Reference	Question	Kent County Council's response
CA1.42	Special Category Land - The ExA is minded to recommend that the circumstances set out in s131(4) or 132(4) related to replacement land; 131(5) or 132(5) relating to area, or use and necessity of replacement land; 131(4A) or 132(4A) relating to availability of replacement land and public interest for a speeded procedure; or 131(4B) or 132(4B) relating to acquisition for a temporary purpose do not apply in relation to plots 185b, 185c, 185d, 185f. Show any evidence to the contrary.	KCC has no evidence to the contrary.
CA.1.43	Special Category Land PA2008 s132(3) states that this subsection applies if order land, when burdened with the order right, will be no less advantageous than it was before to the persons in whom it is vested, other persons, if any, entitled to rights of common or other rights, and the public. Set out your reasoned opinion as to whether this subsection is fulfilled in the case of the Special Category Land at plots 185b, 185c, 185d, 185f.	The County Council has looked at the plan and, other than highway land and a public right of way, does not appear to have any land affected within the plan. The County Coun

Manston - Haine Link
Land for Safeguarding
Sheet 1

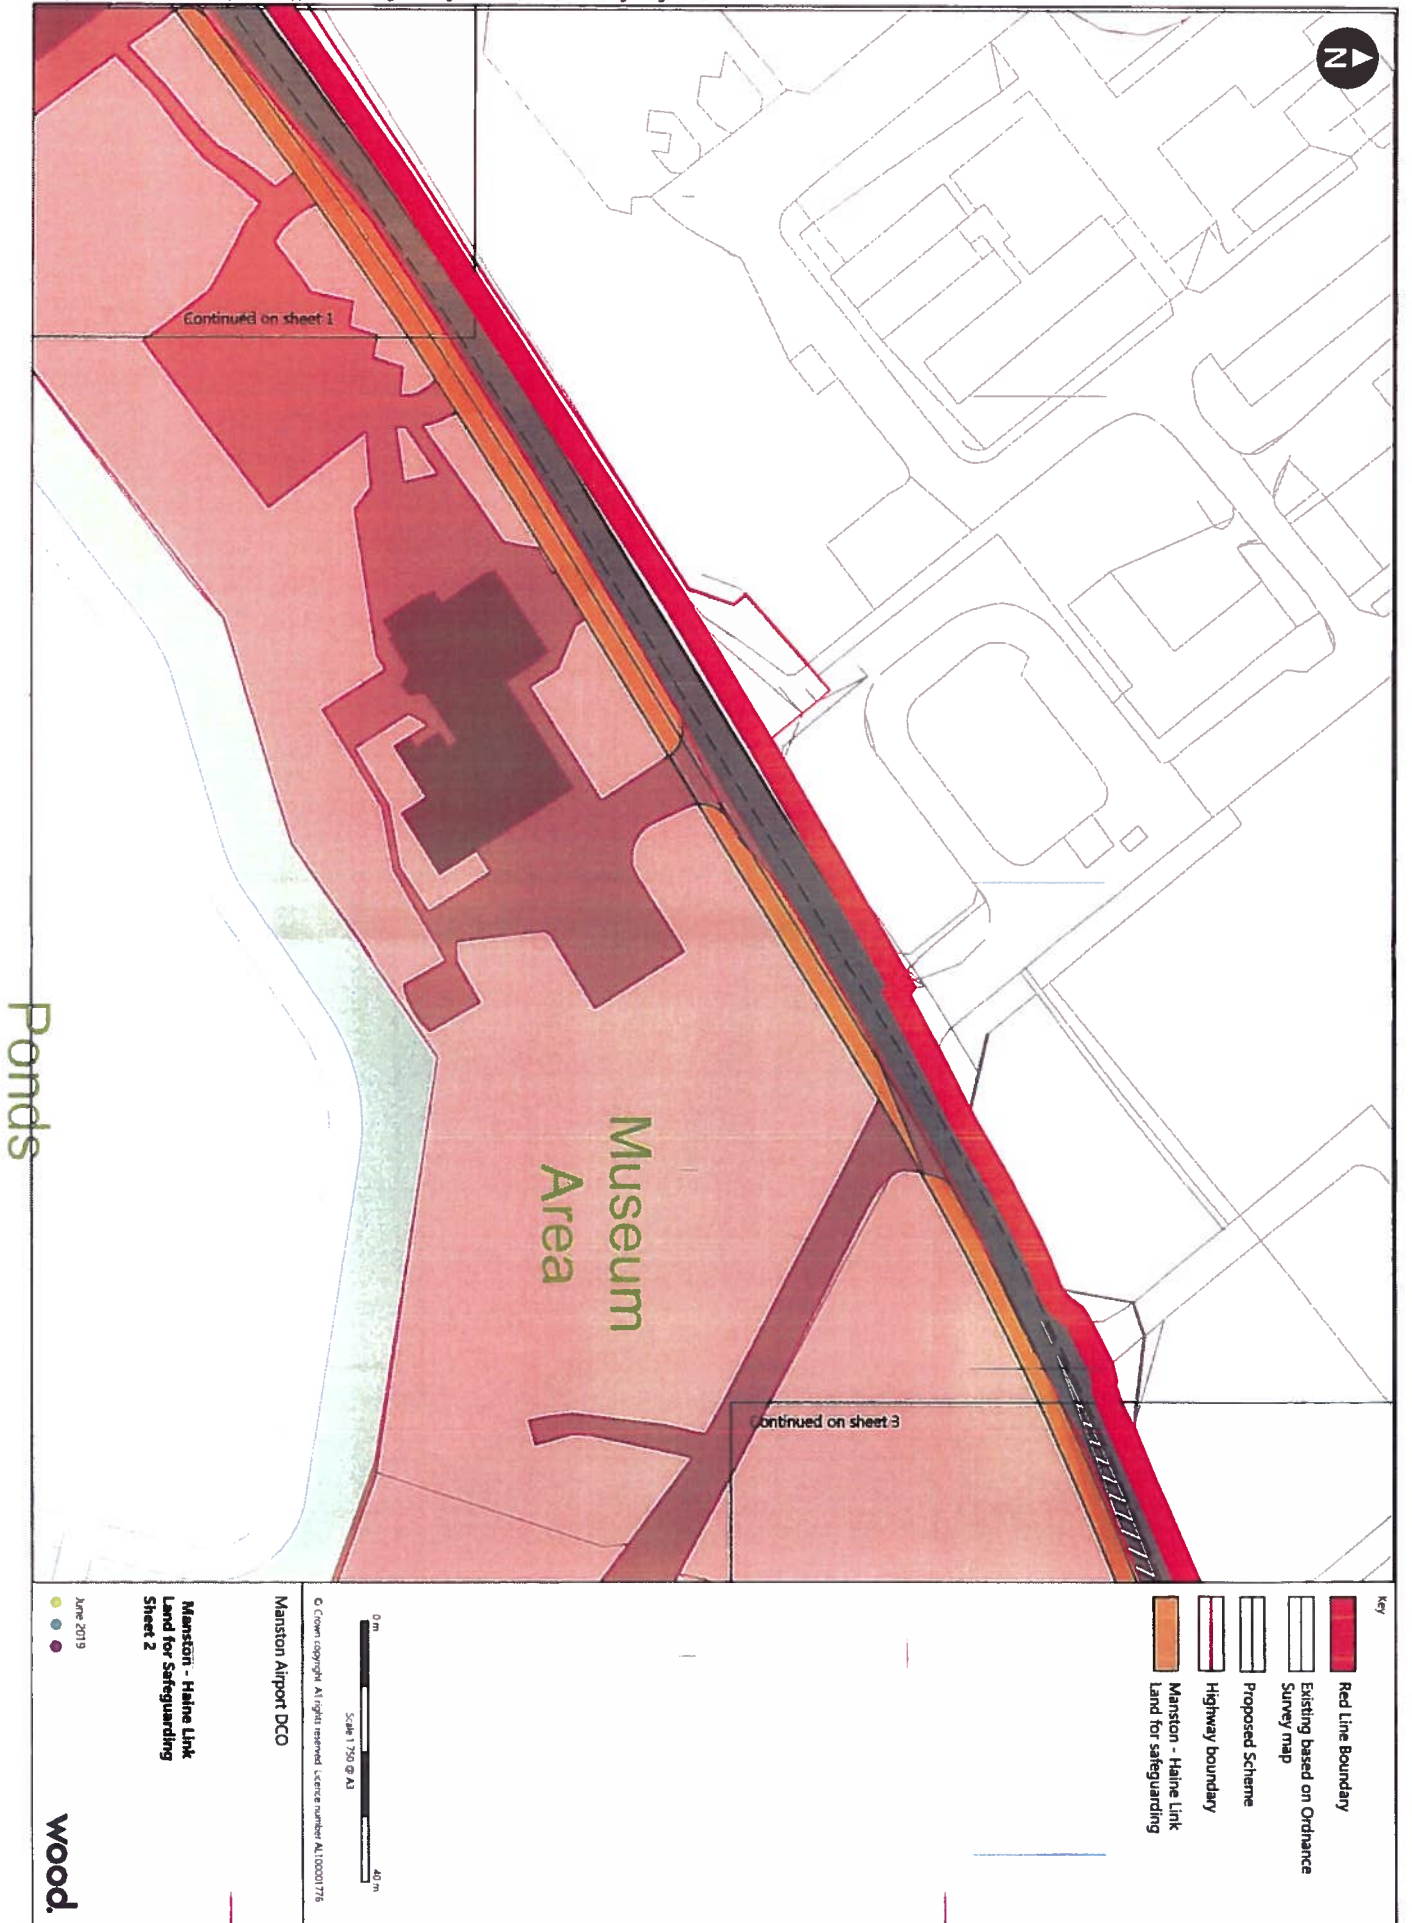
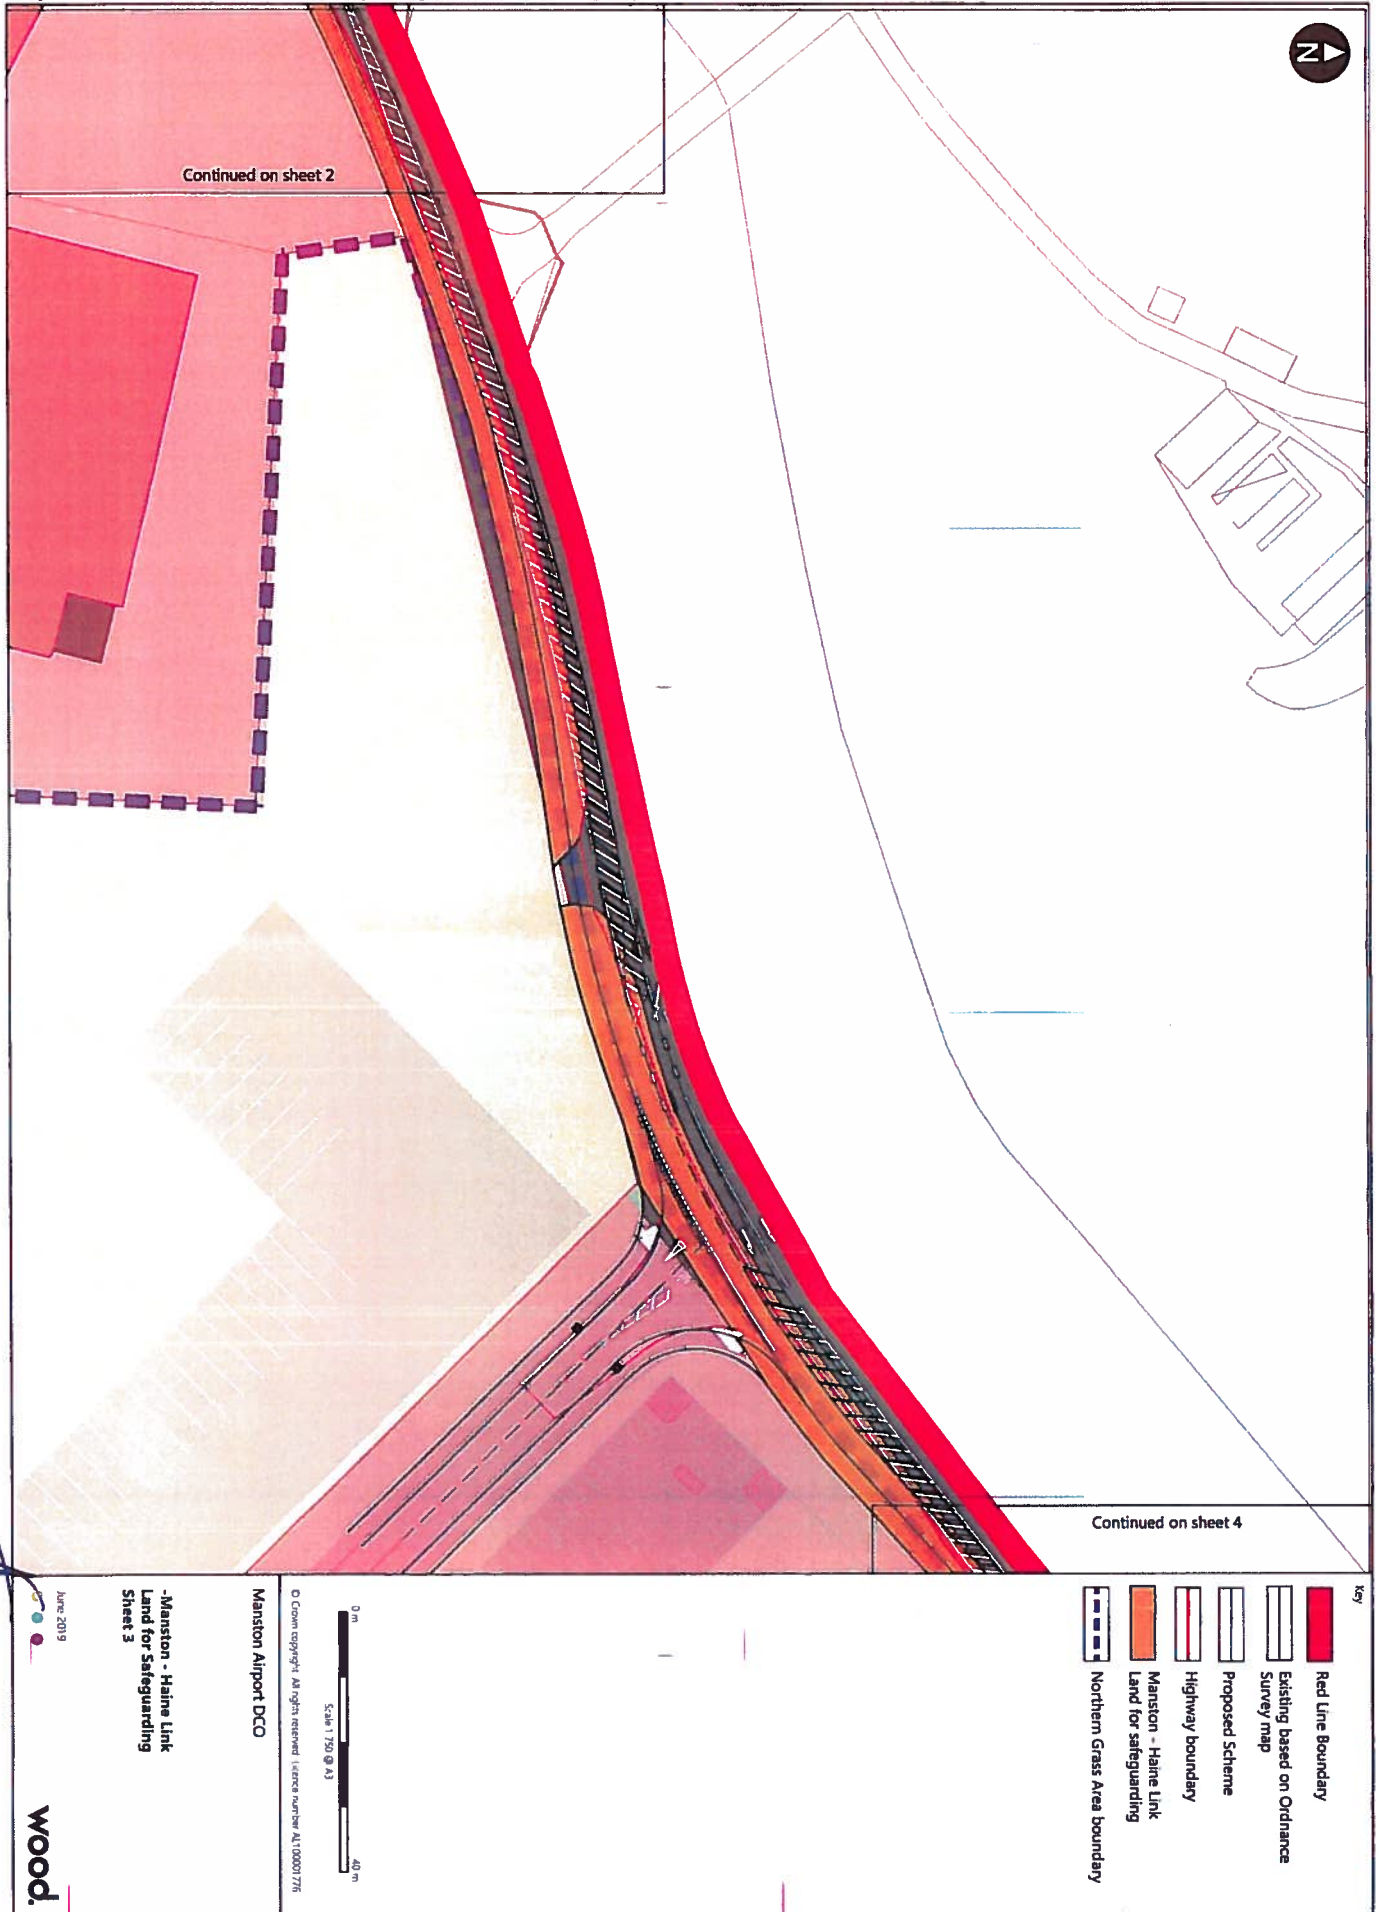
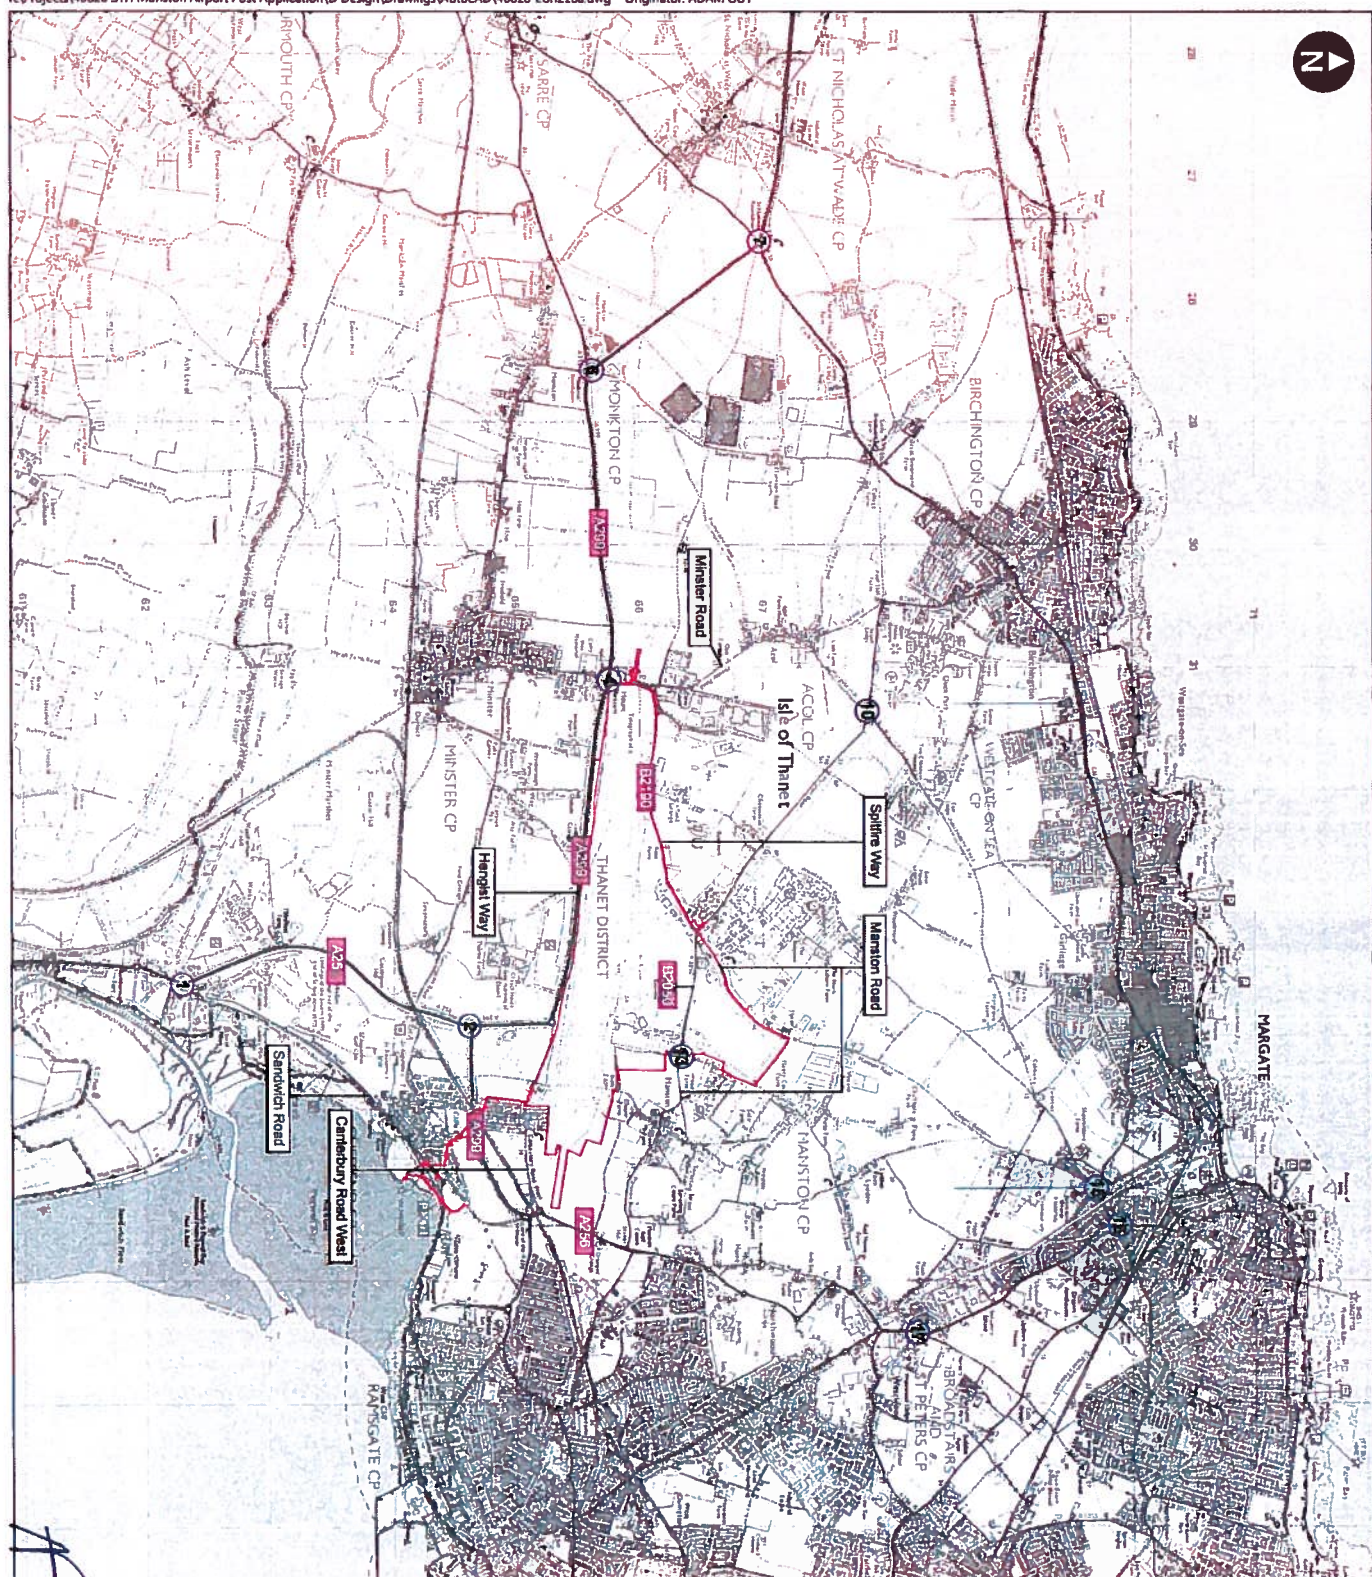
The applicant has expressed their requirement for the proposed road link to be realigned, to avoid the need for it delivered through the centre of the Northern Grass and as such, the current masterplan for the site does not propose to facilitate the continued development of this important highway route, which in turn could lead to a significant increase in the amount of off-site works required to deliver infrastructure and increased costs.
The County Council, as Highway Authority, has requested a statement of justification/reasoning for this position (given that the indication from the applicant is that the Northern Grass is not intended to form part of airside development), however this has yet to be provided. In the absence of clear and compelling justification, the Highway Authority is of the opinion that the original alignment of the Manston Road to Haine Road

link should be included as part of any internal masterplan for the Northern Grass and an

agreed route corridor secured as part of any development proposal for this site. This will also facilitate delivery of infrastructure by the Highway Authority, should external funding for this infrastructure be obtained/awarded ahead of any built development within the site being delivered.

Notwithstanding the above position in relation to the lack of clear and compelling justification from the applicant for precluding delivery of a route through the Northern Grass, the Highway Authority has entered into initial dialogue with the applicant to explore the possibility of an alternative alignment for the Northern Grass section of the Manston Road to Haine Road link, should the DCO be approved without the requirement for on site delivery. Initial design process has suggested that this route would largely avoid the majority of the Northern Grass and utilise the existing Manston Road corridor to the west of the site (with appropriate improvements to the geometry and carriageway/footway construction of this route).

To date, this process has yet to be fully concluded to the satisfaction of the Highway Authority. Moreover, it is currently unknown what impact an alternative route will have on scheme cost and third-party land requirements.

MasterPlan - the concerns relating to the A256 Haine Road to B2050 Manston Road link have yet to be resolved. This is outlined in answer Tr.1.18. This extends to the concerns over the lack of appropriate links to Westwood (by all modes of transport).
